Colin Haigh, Head of Planning
Welwyn Hatfield Borough Council
14th January 2016
Dear Sir

APPLICATION REF: 6/2015/2515/PN3
TOWN AND COUNTRY PLANNING ACT 1990 TOWN AND COUNTRY PLANNING
(GENERAL PERMITTED DEVELOPMENT) (ENGLAND) ORDER 2015

I understand you have received Prior Notification of development at Nyn Manor dated 22nd December 2015 and my objections to the Council giving Prior Approval are as follows:-

GROUND FLOOR PLAN

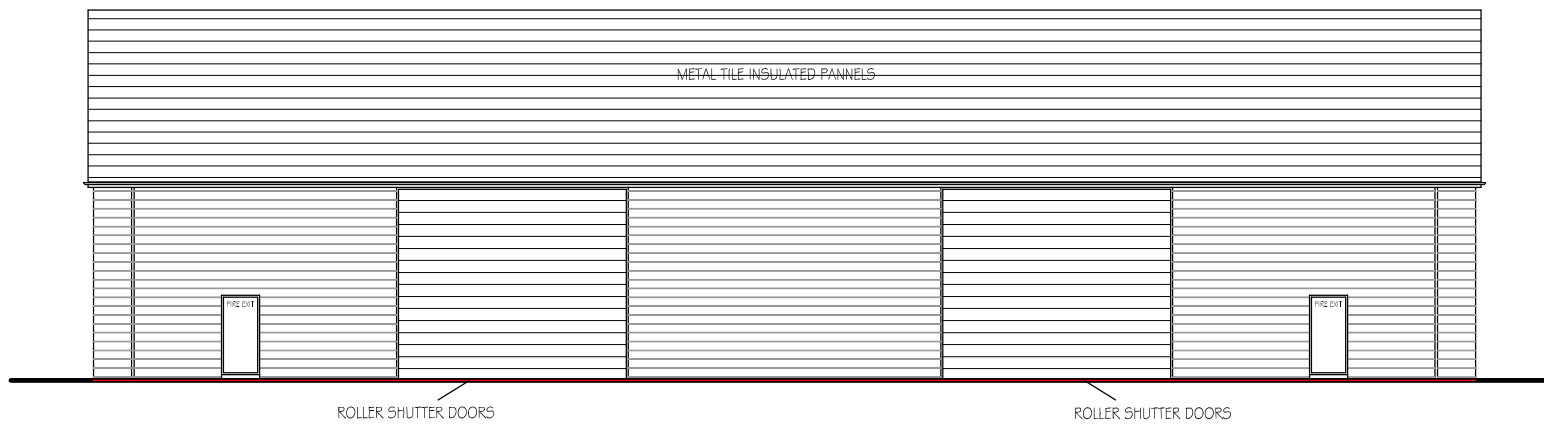
The GROUND FLOOR plan shows non-standard bay widths of 7.3 metres, these are usually 6 metres in barns. The large ventilators on the sides are not necessary where a barn is used for storage. Hay must be dry before it is stored otherwise it becomes combustible. Is there a genuine and sustainable need for this size and design?

FRONT ELEVATION

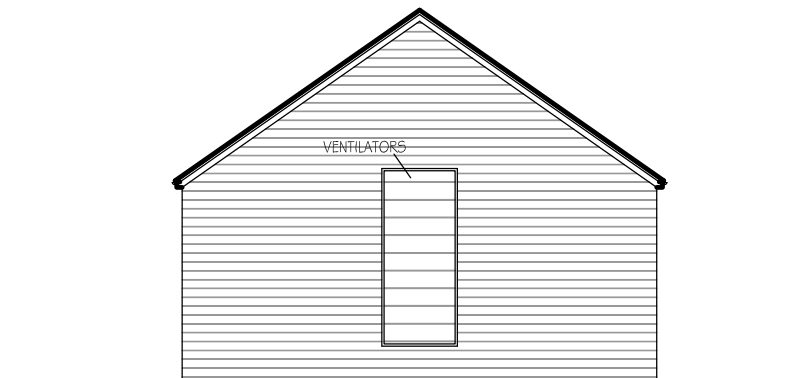
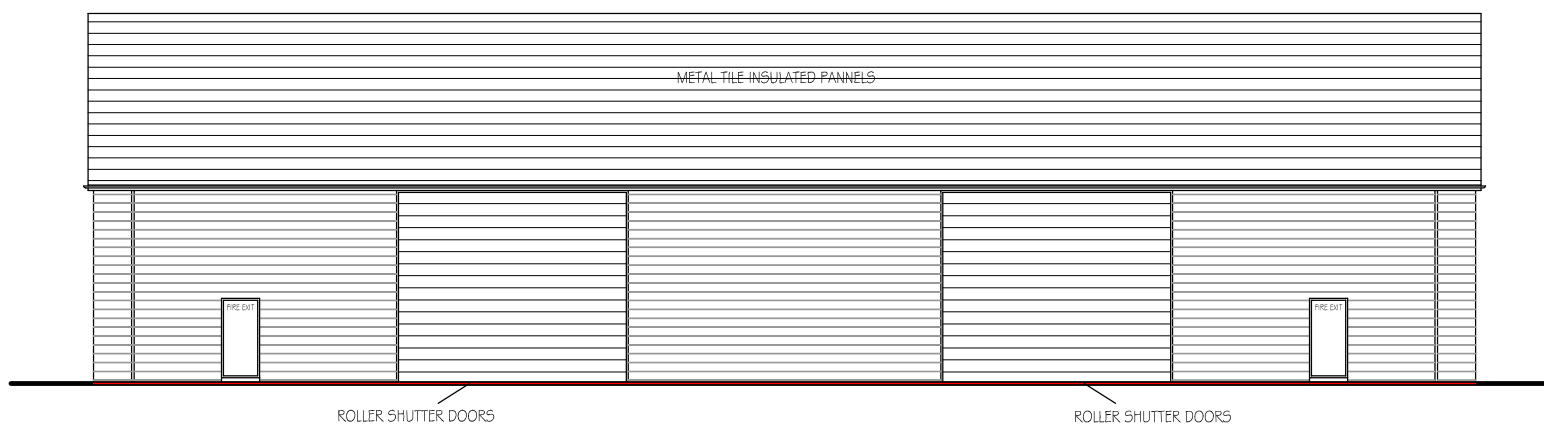
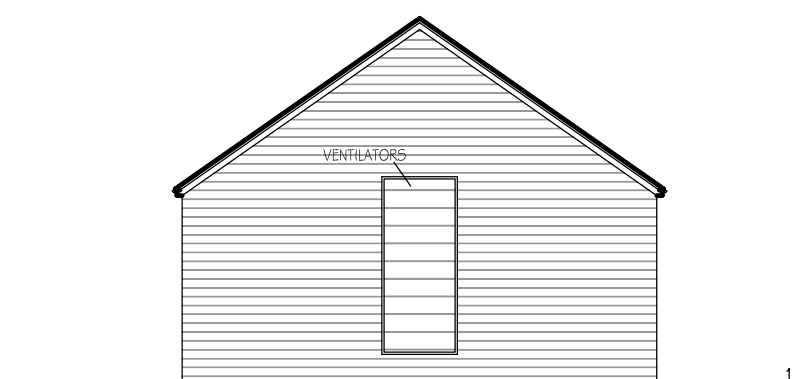
The proposal to erect a structure over 30 feet high on undulating land and positioned on the highest point of the northern boundary and probably the highest point near the western boundary of the site means that not only will it be harmful and objectionable to the visual amenity of the immediate surrounding area but it will also have a detrimental impact from further afield. PPG7 Para. E27 states 'Sites on skylines should be avoided if possible'. It is also positioned in close proximity to the established residential development along The Ridgeway.

Under PPG7 E16, the Council should consider whether this is a genuine and reasonable development. Under PPG7 E24, the Council may concern themselves with the siting, design and external appearance of a proposed new agricultural building. This building is a bespoke design by an architect who usually designs residential properties and barn conversions. The roof pitch is around 35 degrees whereas the pitch for a portal frame building is usually 8-15 degrees; a 35 degree pitch would not be unusual for a tiled roof on a house.

PPG E30 E31 and E32 should be considered with regard to the red tile insulated roof and walls covered with black cladding, no details given, which will stand out in prominent isolation and not blend into its surroundings.
